**From:** Thomas Watt  
**Sent:** Wednesday, 21 December 2016 10:54 AM  
**To:** Garry Bailey; Murphy, Simon  
**Cc:** Gen Seed; Megan Dawson; Howard Reed  
**Subject:** Rixs Creek Extension Project (SSD 6300) - request for additional information

We have reviewed the RTS received on 21 October 2016 and consulted with relevant government agencies (agency submissions on the RTS are available from our website [here](#)). As discussed earlier this morning, we require additional information in relation to several aspects in order to finalise our assessment.

Decline in Uppermost Water Table – Cumulative Impact

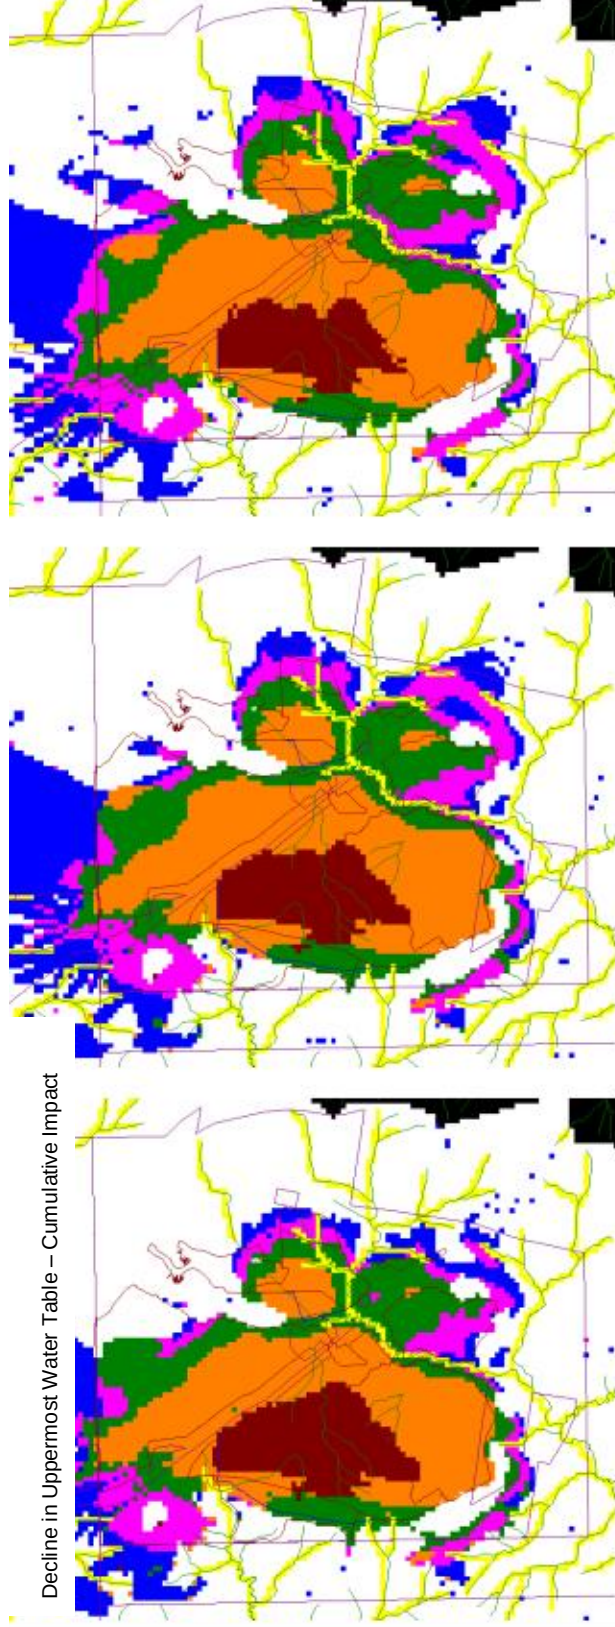
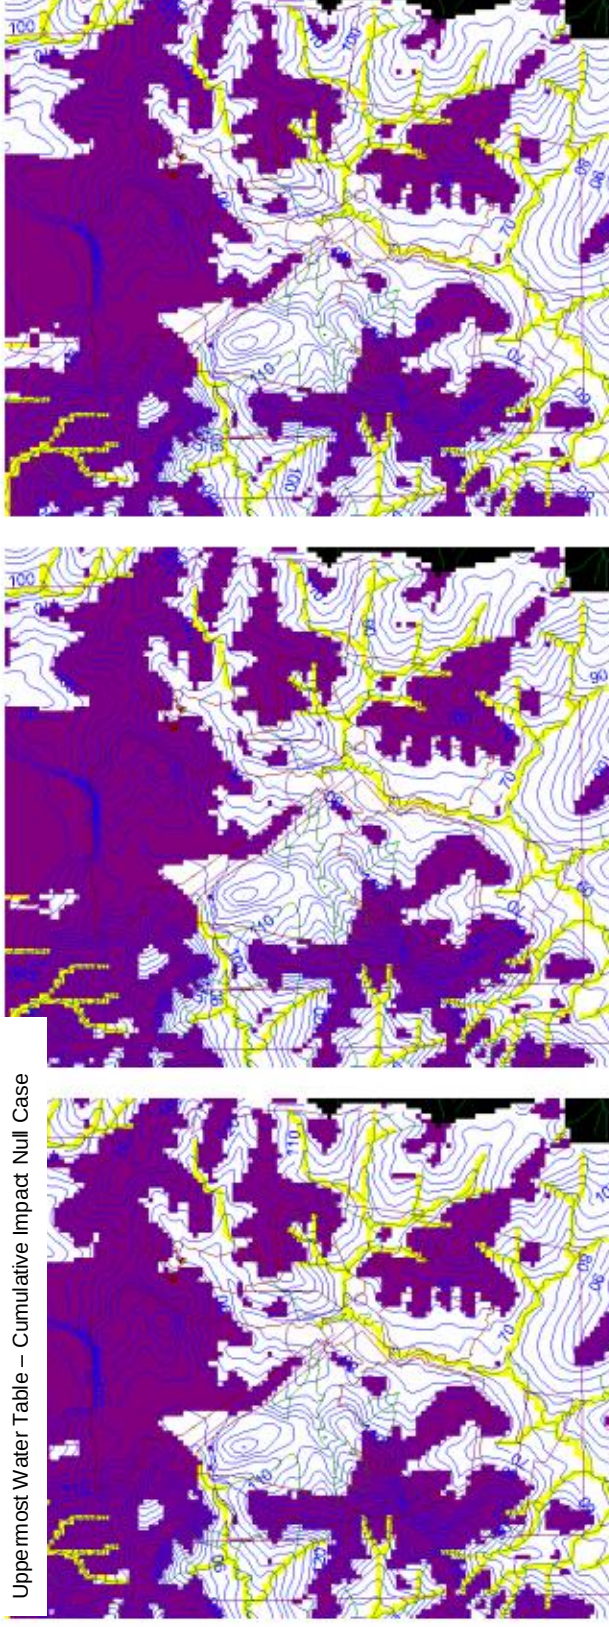
- c) The GIA states on page 53 that cumulative drawdown in the uppermost water table propagates to the north and would not have an impact. This statement needs to be supported by analysis and discussion.

RECOVERY MODEL – HYDROSTRATIGRAPHIC ZONES FIGURE 8.29

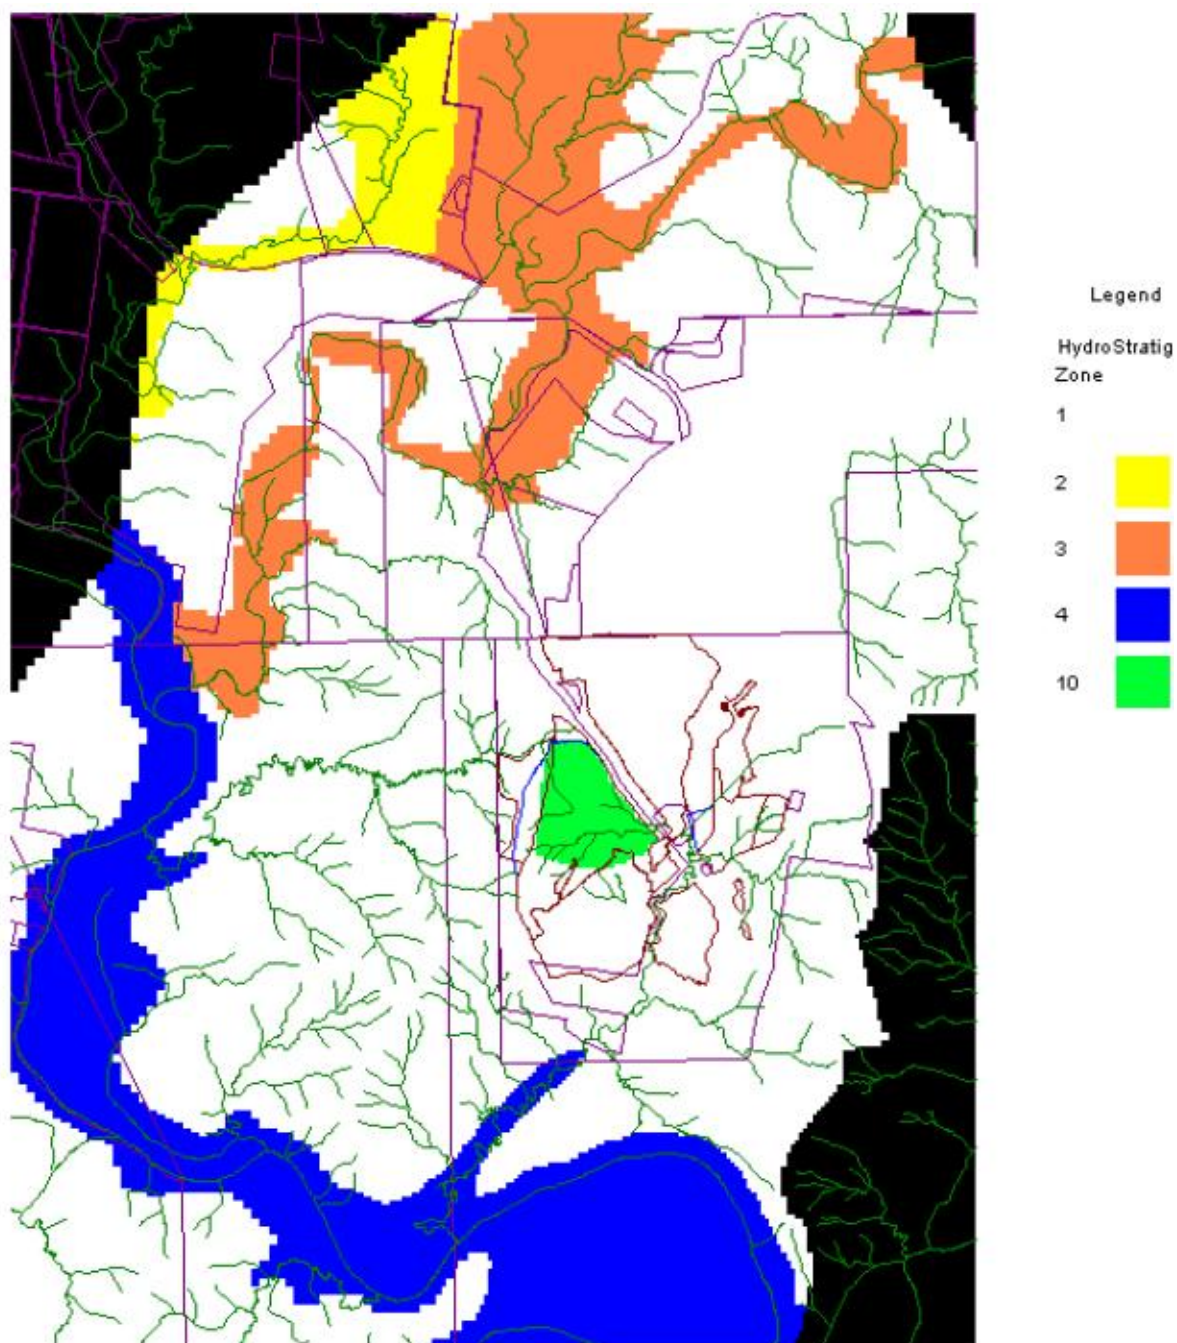
- b) on page 50 of the GIA report, the following statement is made: "The groundwater contribution from hard-rock (HSU Zone 1 in Figure 8.29) to the Hunter River Alluvium (HSU Zone 4 in Figure 8.29) is predicted to be 244 m3/d at the end of the recovery simulation. This demonstrates a minimal groundwater contribution to the Hunter River alluvium". It is unclear from this statement and the preceding statement in the GIA report, which refers to the void, whether this is describing the predicted discharge (seepage) of saline water from the final void to the Hunter River alluvium, via the hard rock groundwater source, or some other water source. Additionally, it is unclear how this has been determined to be a minimal impact to the Hunter River alluvium and a more detailed explanation as to

how this conclusion was reached is requested. Please provide any estimated water quantities in ML/day or /year.
